CITY OF ALBUQUERQUE

June 7, 2006

RE: ANCALA VILLAGE TOWNHOMES (F-21/D76)
Engineers Certification for Release of Financial Guaranty
Approved Engineers Stamp dated 05/20/2005
Engineers Certification dated 06/05/2006

RETAINING WALL/CHANNEL/ GARDEN WALL INTERFACE
(DETAIL A-A)

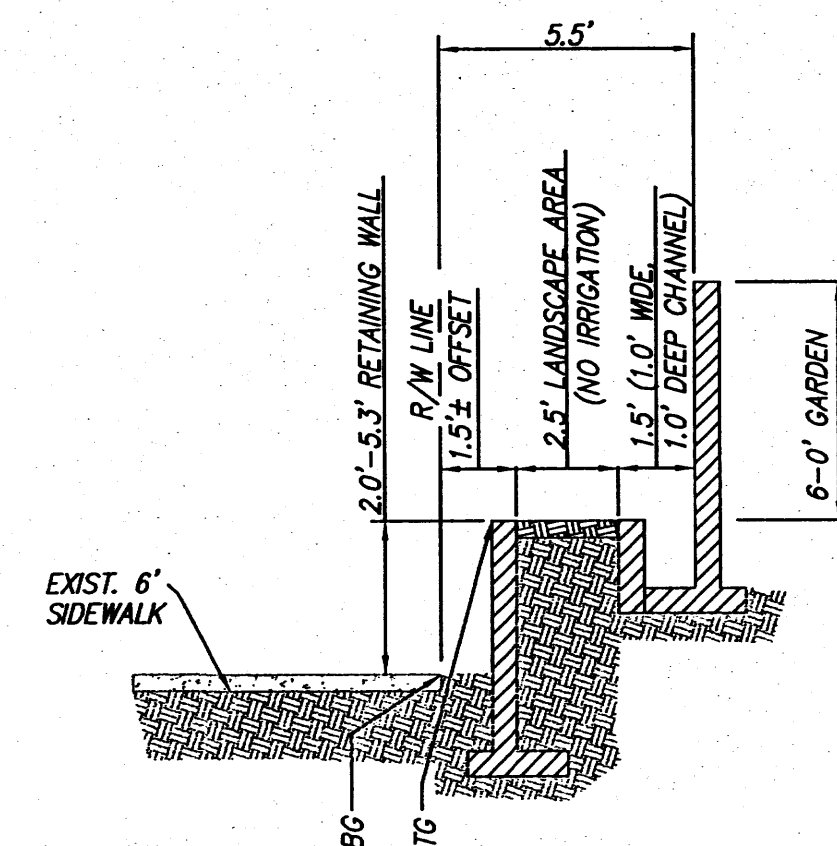
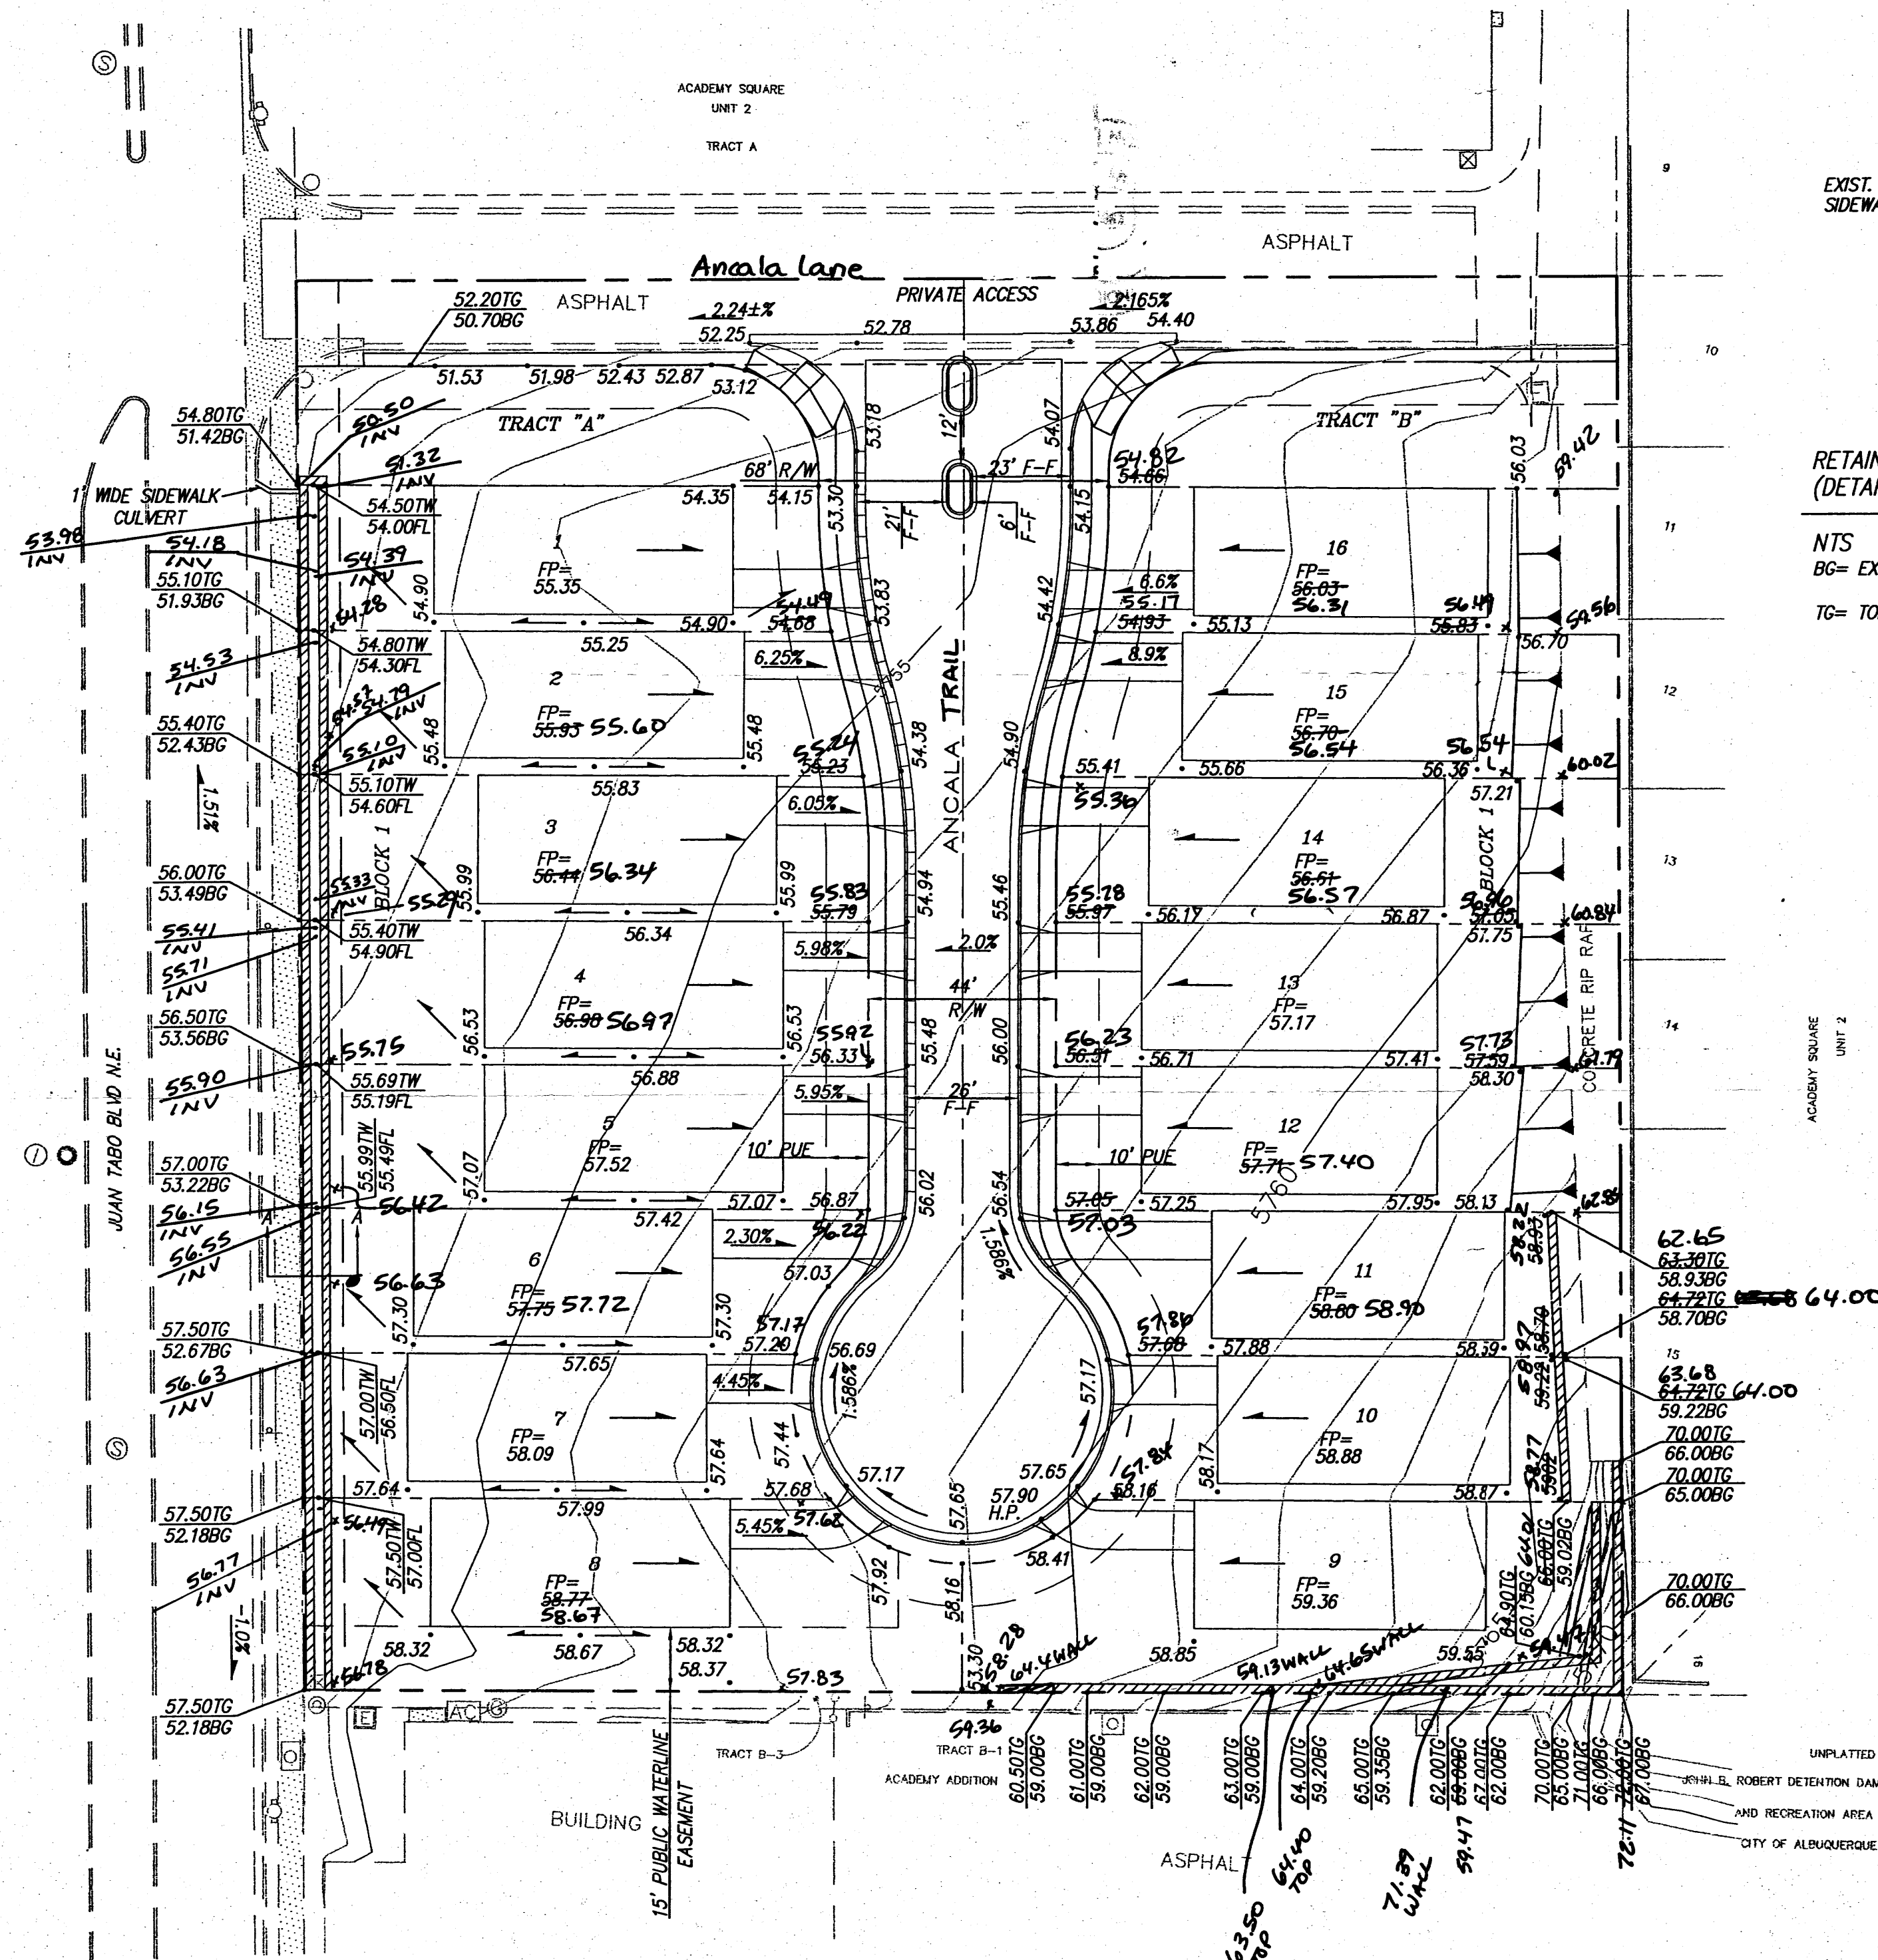
- Increase the size of the sidewalk culvert to 2'-0" and add to Infrastructure List.
- Detail backyard concrete channel so that it is independent of the garden wall.
